WEST SUSSEX COUNTY COUNCIL CONSULTATION

TO:	Arun District Council FAO: Emma Sheppard
FROM:	WSCC – Highways Authority
DATE:	10 th April 2025
LOCATION:	Land at Oldlands Farm Newlands Road Bognor Regis PO22 9NN
SUBJECT:	BE/16/25/RES Approval of reserved matters following outline consent BE/150/22/OUT comprising of 3 No. units within Class B2 and/or B8 of the Use Classes Order (including ancillary office provision) with associated enabling works, parking, landscaping and sustainable drainage system with access off Newlands Road. This application is in CIL Zone 4 (Zero Rated) as other development.
DATE OF SITE VISIT:	Site known to officer
RECOMMENDATION:	Advice

NOTES:

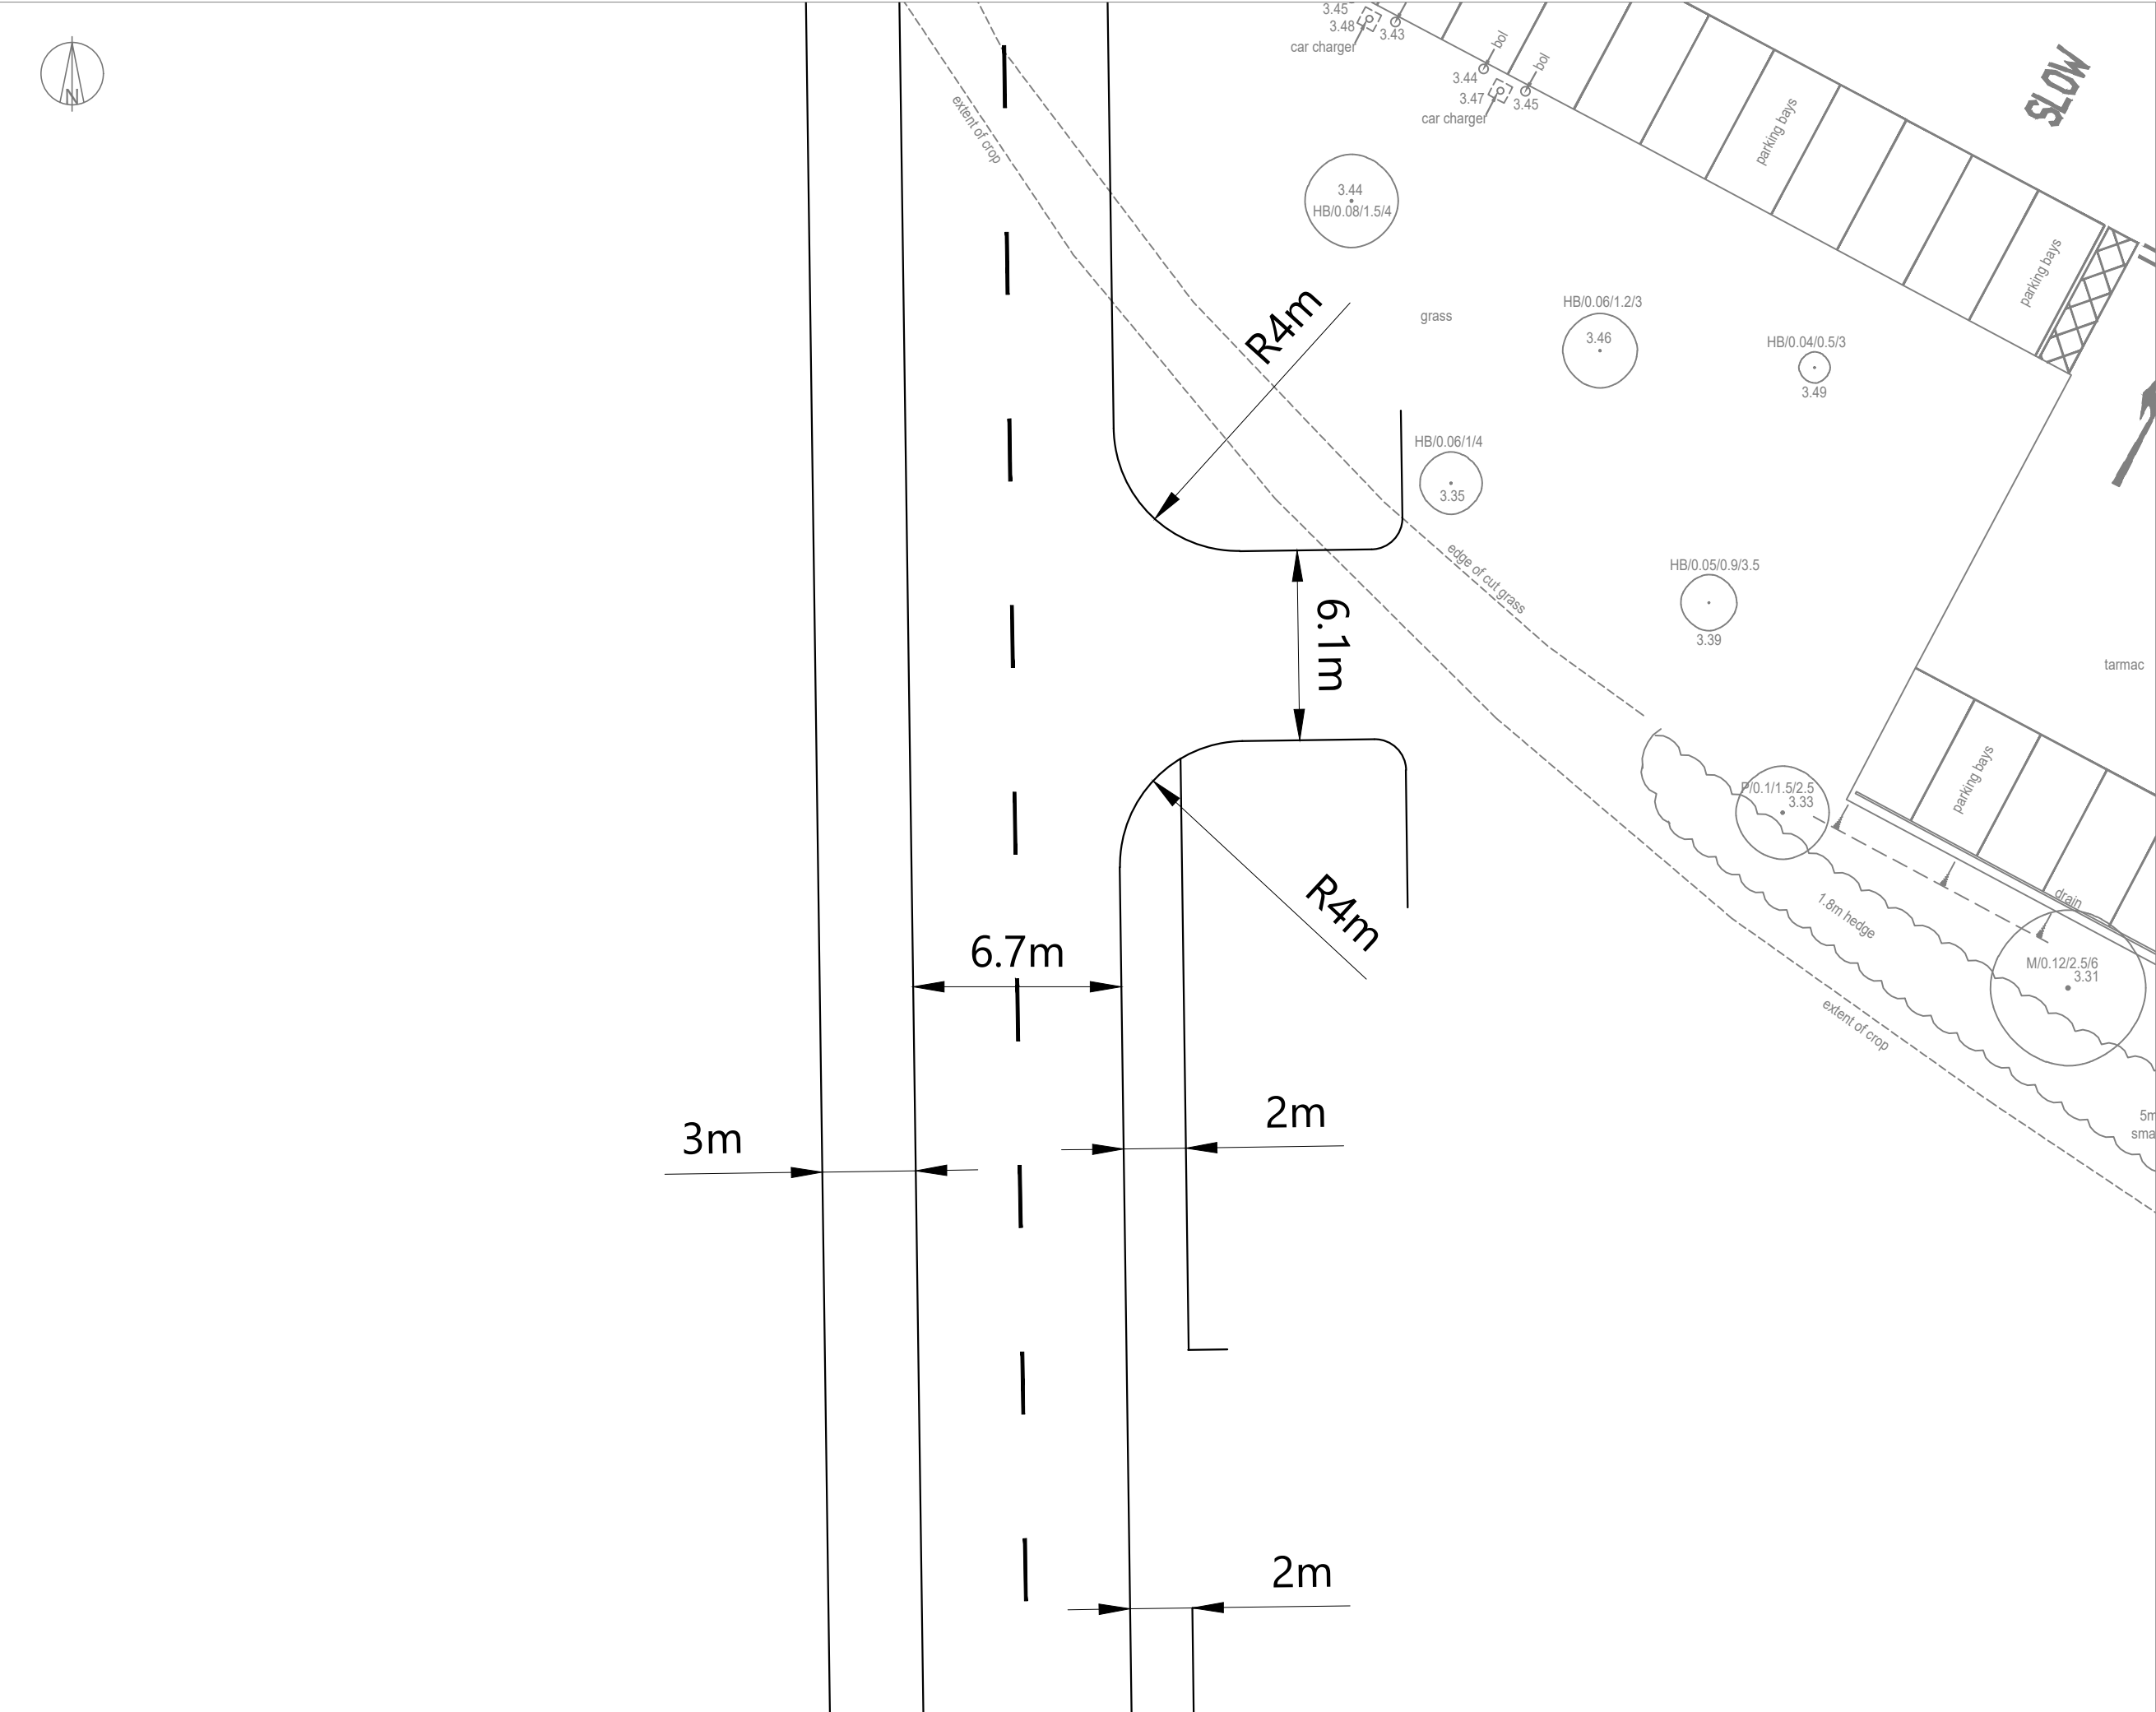
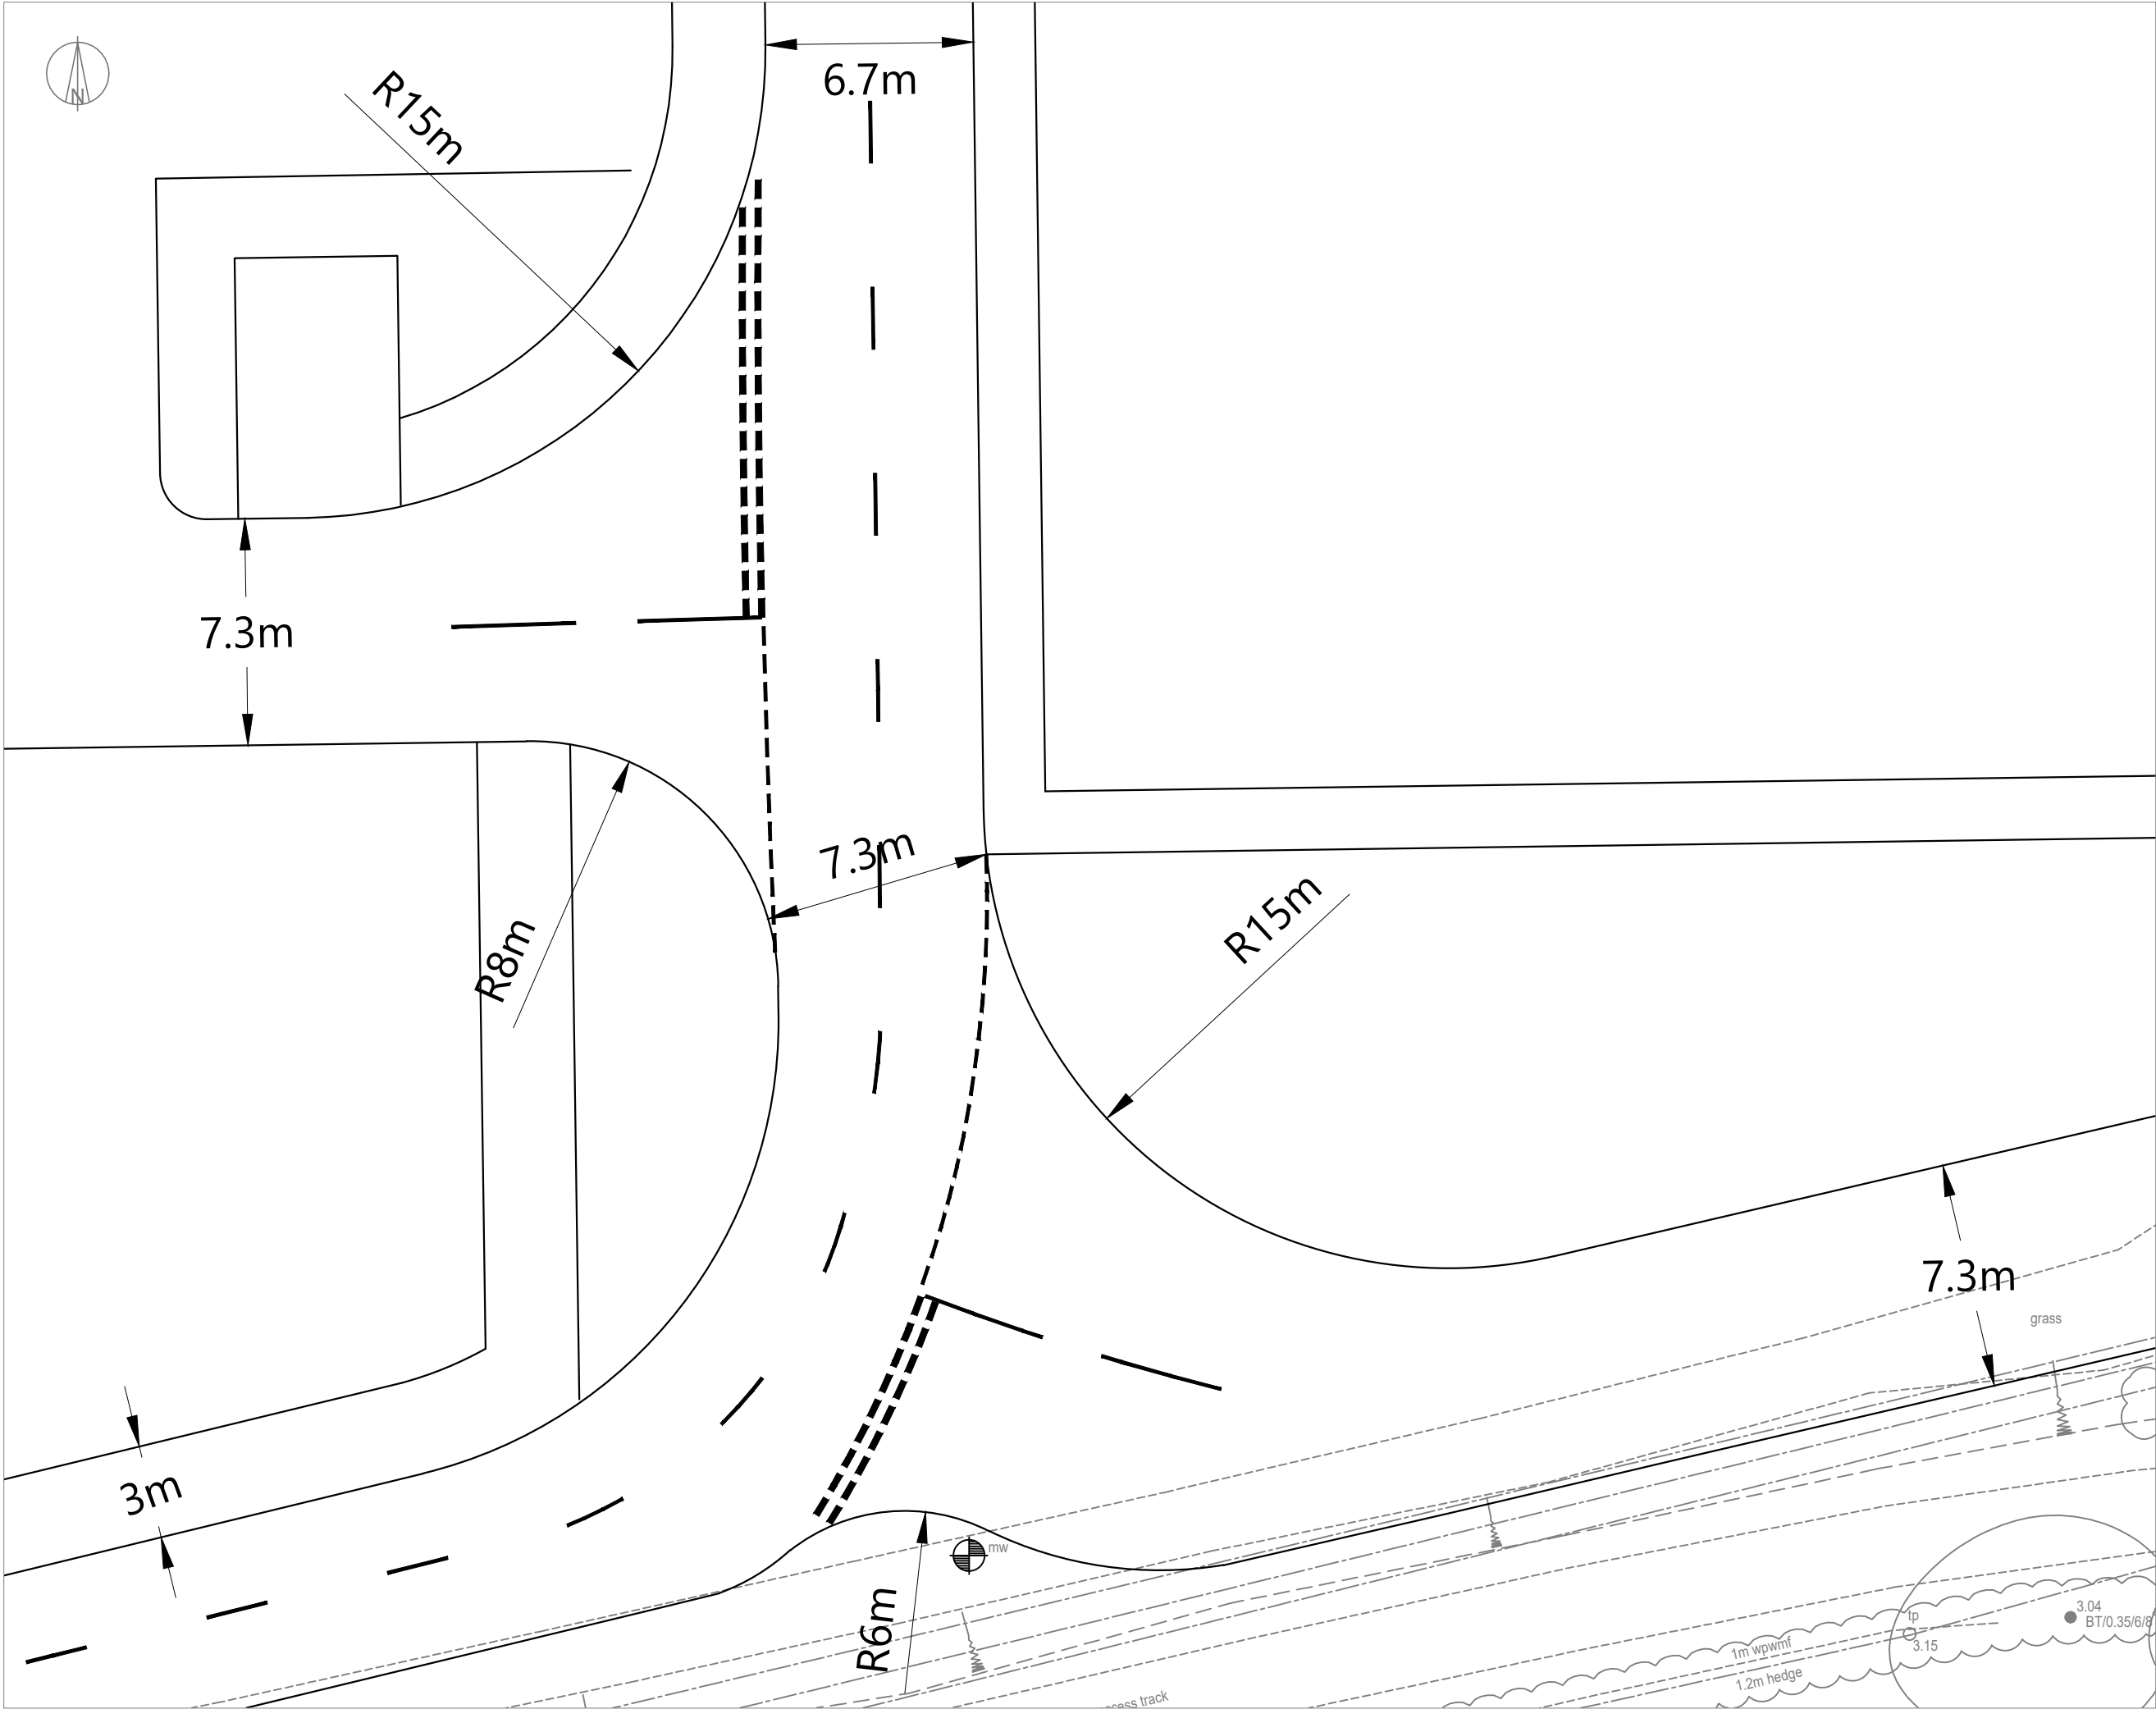
- Dropped tactile paving crossing points should be provided at each point of access across each access point. This does not appear to have been shown on the submitted drawings and should be added.

Subject to tactile paving being added at the access points the LHA is satisfied with the information submitted in of this RM application. A suitable condition has been added at the below to cover off this point.

No part of the development shall be first occupied until the road(s), footways, crossing points and casual parking areas serving the development have been constructed, surfaced, and drained in accordance with plans and details to be submitted to and approved by the Local Planning Authority.
